From: [REDACTED]
Sent: 04 December 2025 10:01
To: Susan Haley
Subject: Re: WA/94/25/HH - 2 Henty Close, Walberton

Following a review of the application WA/94/25/HH we believe the description does not accurately describe the proposal.

Rear Elevation

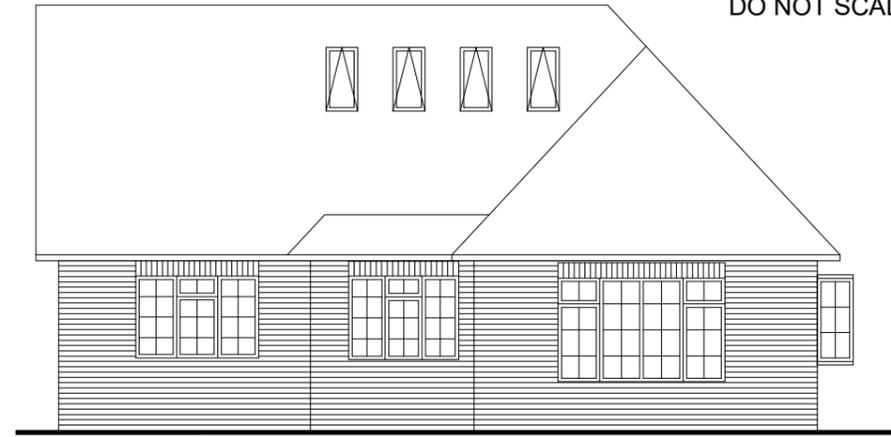
From the plans submitted we believe a more accurate description would be 'Pitched dormer to side of property and loft conversion, consisting of two hip to gables and flat roofed **first-floor extension** to rear of property'.

I have included that that we believe propose a flat roofed first-floor rear extension and not a flat roofed dormer.

Rear Elevation

Thank you for reaching out to me regarding this. I can confirm I am happy for you to amend the description to the below.

Section A-A

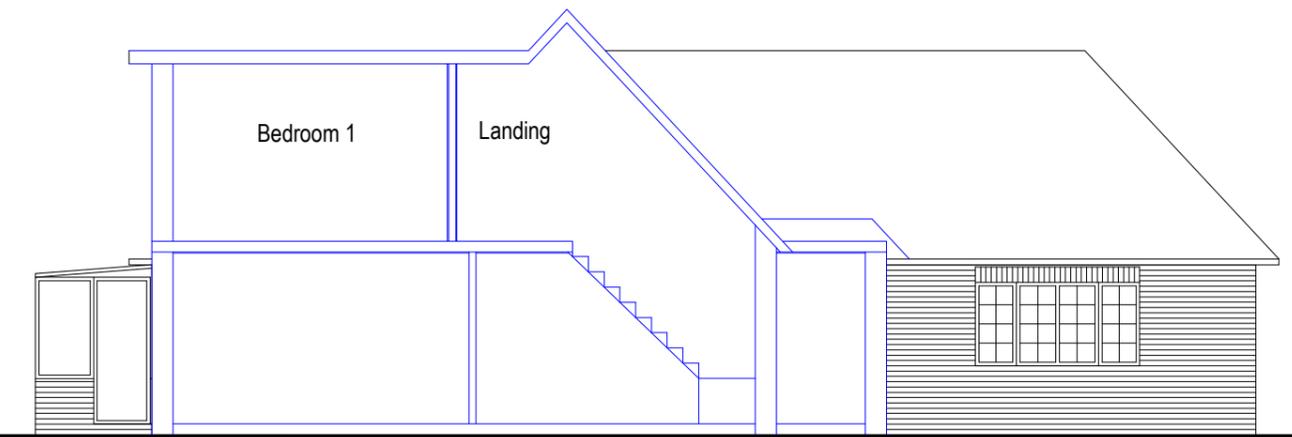
Section A-A
